Recommendation Report for Consent to Display an Advertisement(s)

REF NO: BR/16/25/A

LOCATION: Land Opposite 54 High Street
Bognor Regis
PO21 1SP

PROPOSAL: Installation of 1 No. illuminated advertising display within communications kiosk with integrated defibrillator.

NWP-KIOSK/001

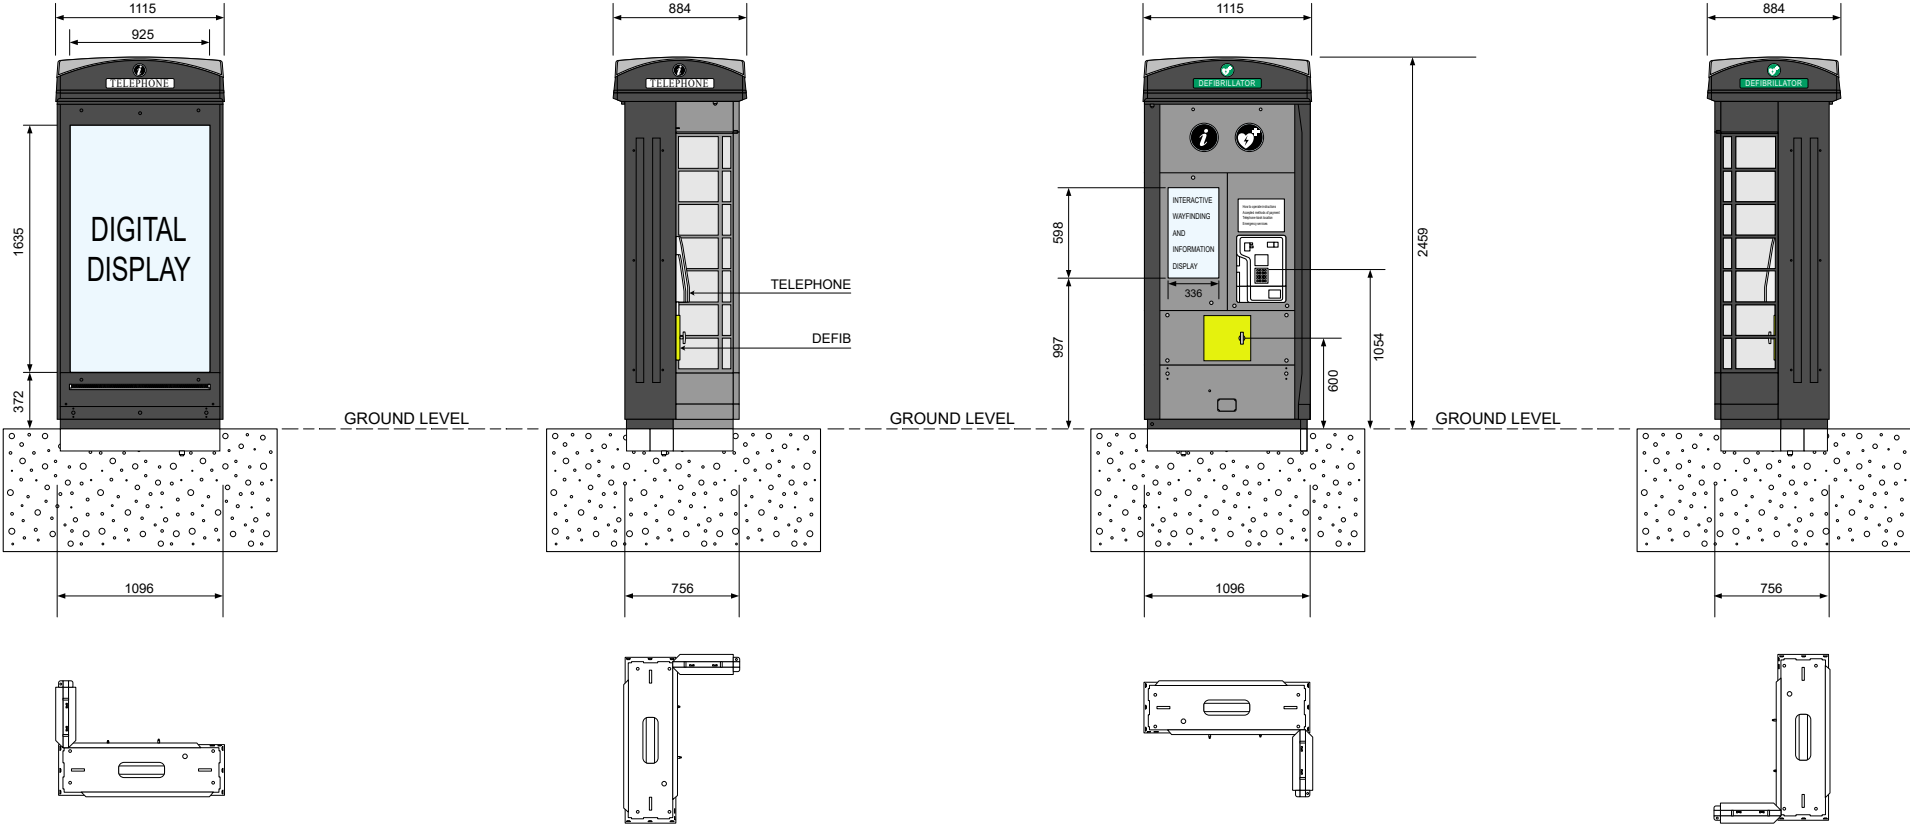
On the reverse (rear) side of the proposed kiosk, a 1635mm tall x 925mm wide digital display for advertising purposes (including Council public information, public health information, and emergency incident messaging) is proposed. The display is a Liquid Crystal Display (LCD), recessed behind 9mm toughened laminated safety glass. The display would portray static advertising images that change every 10 seconds. The display would have an inbuilt sensor control system which adjusts display luminance to ambient light levels. The maximum luminance levels (full white) in darkness would be 300 cd/m² and in daylight would be 3500 cd/m². The illuminance levels are in line with the West Sussex County Council's standing advice for the assessment of illuminated adverts and the display is acceptable in terms of illuminance.

sides of the High Street. The location of the proposal would not be suitable as the display panel for advertising would appear prominent within the street scene, detracting from the existing shopfronts and it would result in harm to the character of the area. It is noted that the High Street is a retail area in which advertisements are not uncommon. However, there are no illuminated display signs present centrally along the length of High Street, therefore the addition of the illuminated display would appear at odds with the wider character and appearance of the street scene.

For the reasons outlined above, the proposed development would detract from the existing shop fronts and would appear prominent within the street scene. The proposal would result in demonstrable harm to the character and appearance of the street scene and is therefore contrary to Paragraph 141 of the NPPF.

The illuminated display screen on the proposed kiosk would be overbearing in the proposed location, drawing attention towards it and would result in demonstrable harm to the character of the locality and visual amenity of the street scene and wider area. The proposed development is therefore contrary to Paragraph 141 of the NPPF.

- 1 The proposed illuminated advertising display, by reason of its siting in the centre of the street would appear prominent, detracting from the existing shop fronts and it would appear at odds with the wider street scene. The proposal would result in demonstrable harm to the character of the locality and visual amenity of the street scene and wider area. The proposed development is therefore contrary to Paragraph 141 of the NPPF.
